Final Report - Corrections Required **Application No. ANEX-24-0006**

Description : Matrix Design Group on behalf of Colorado Springs Equities LLC is submitting a serial annexation petition for seven parcels and Land Use Plan/Rezoning exhibit for a portion of the subdivision known as Rock Creek Mesa.

Document Filename : Rock Creek Mesa Addition No 5_Legal Description_V3_5-13-24

ROCK CREEK MESA ADDITION NO. 5

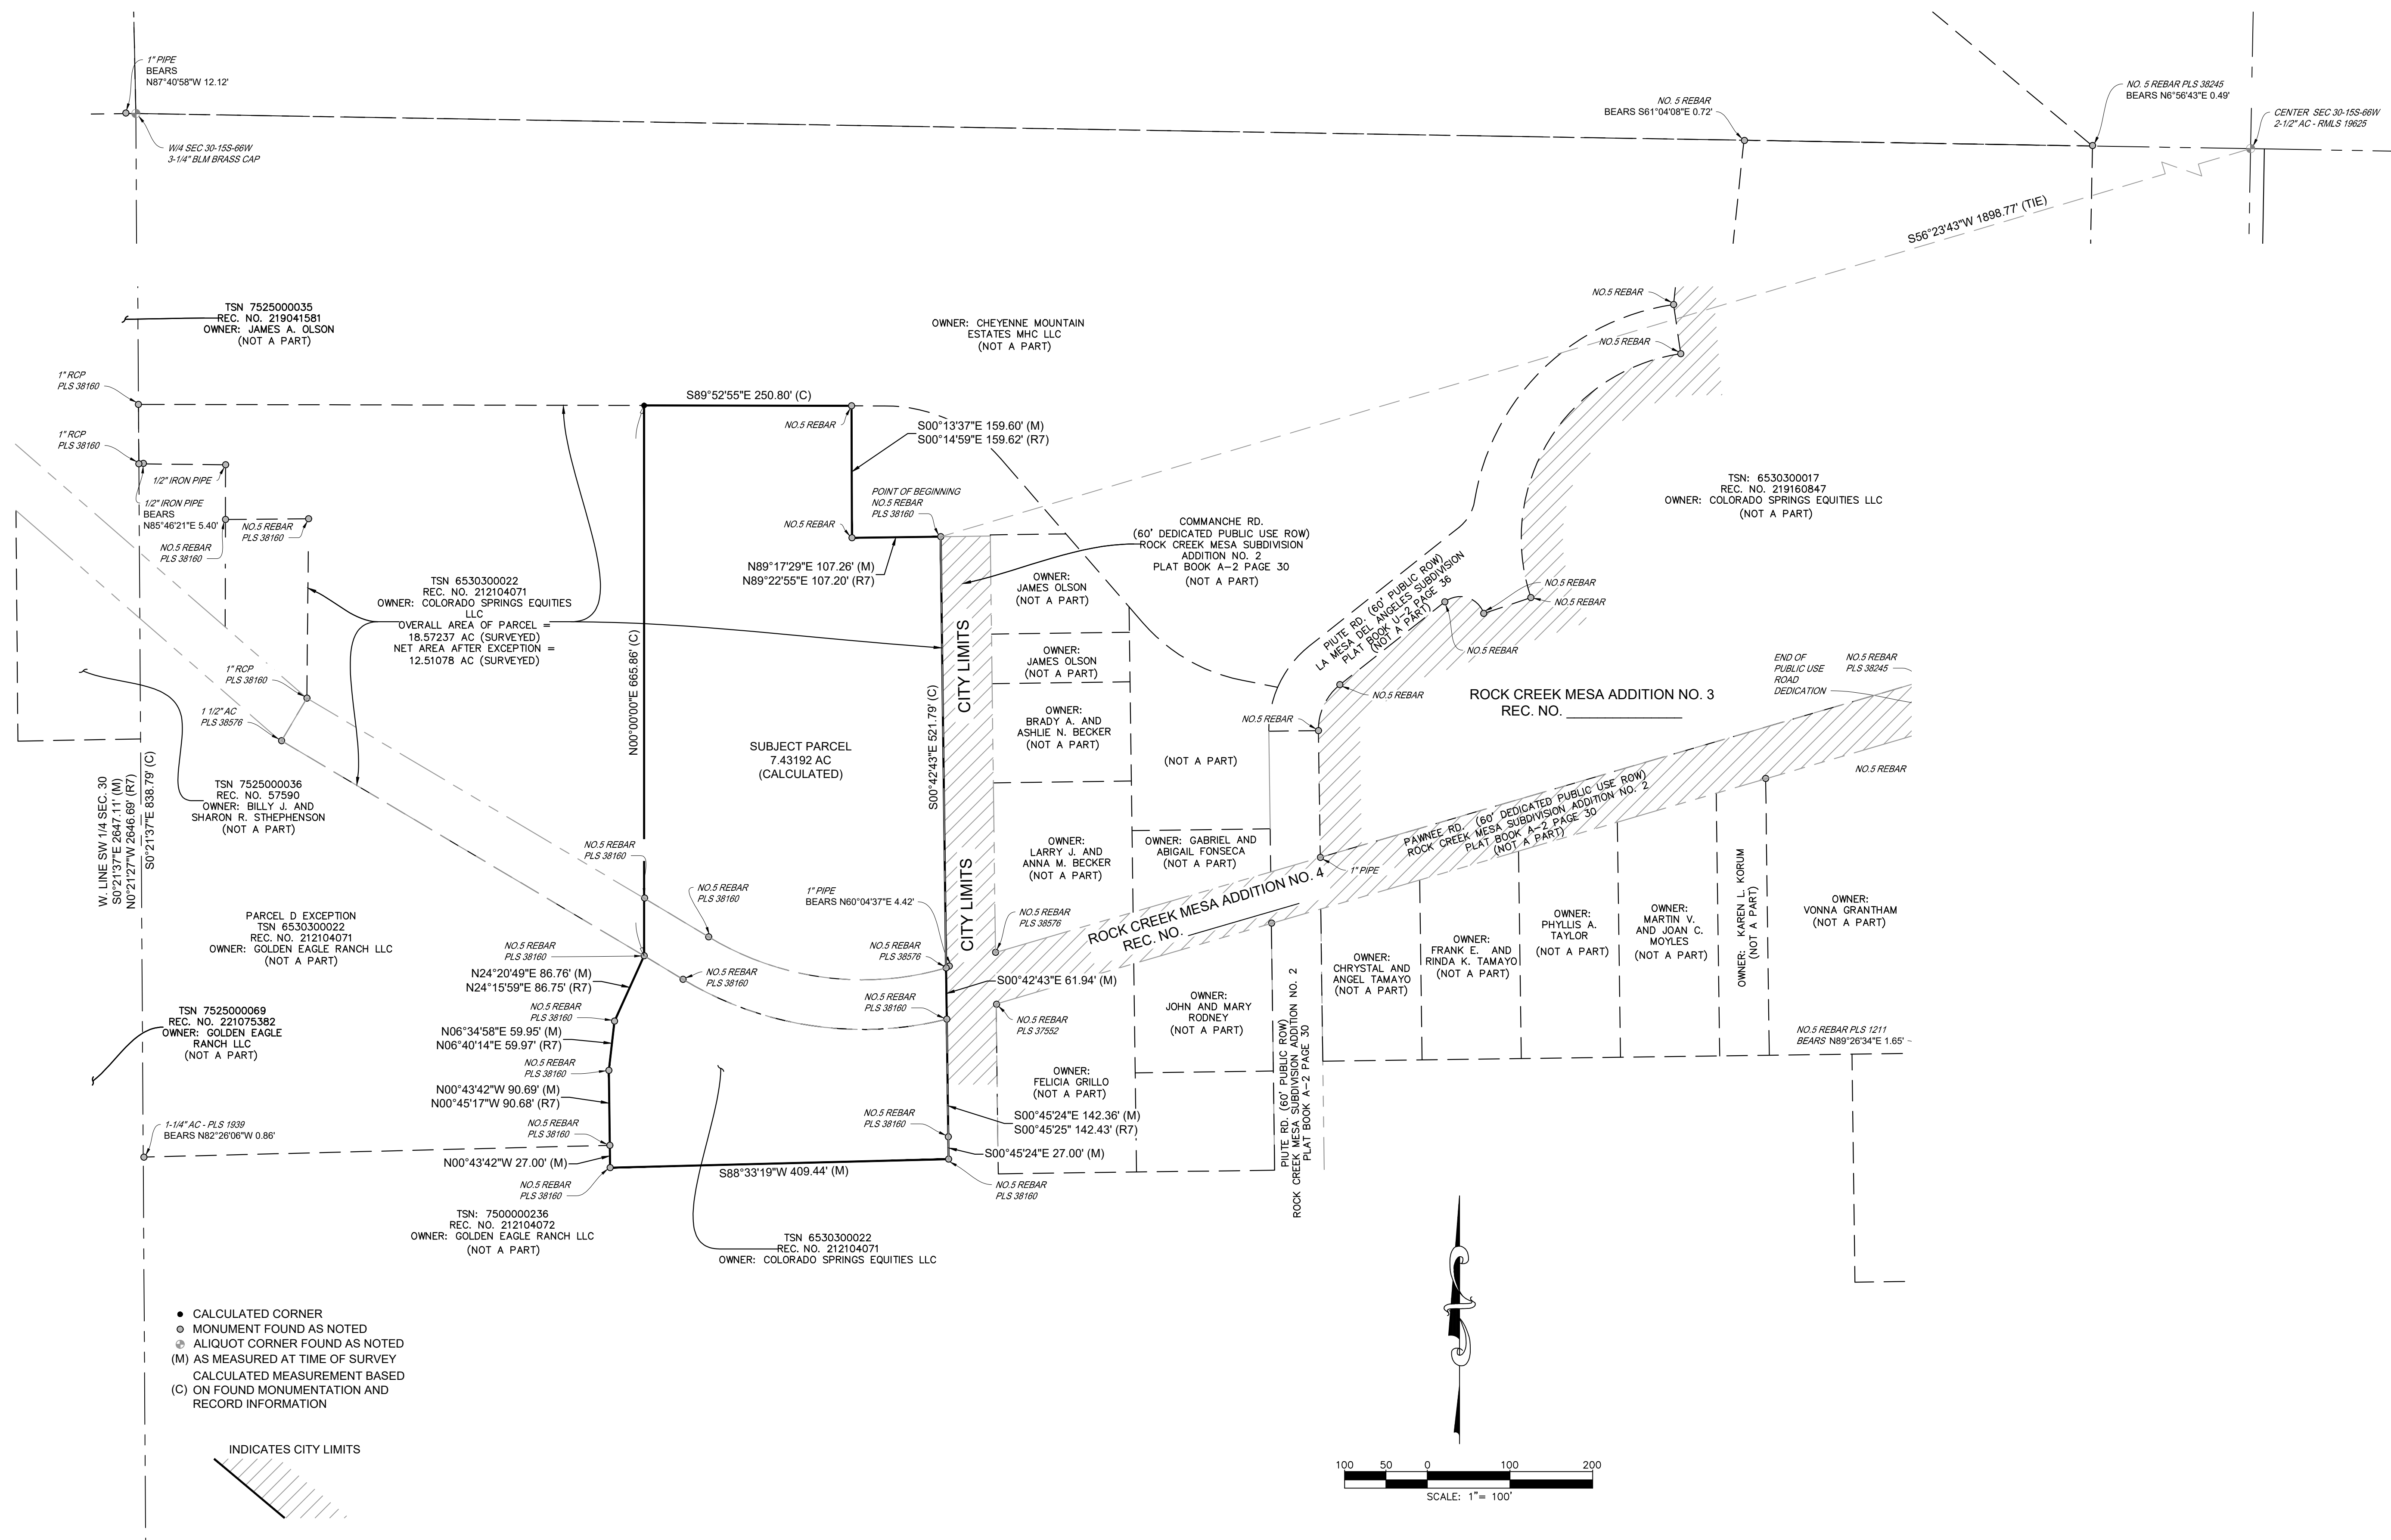
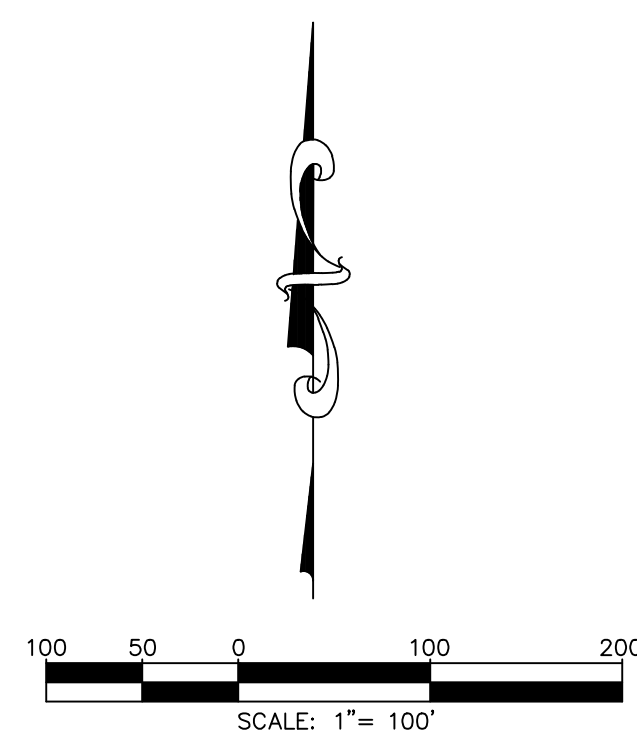
Comment ID	Page Reference	Reviewer : Department	Review Comments
47	1	Gabe Sevigny : Planning	update legal description per Surveyor comments
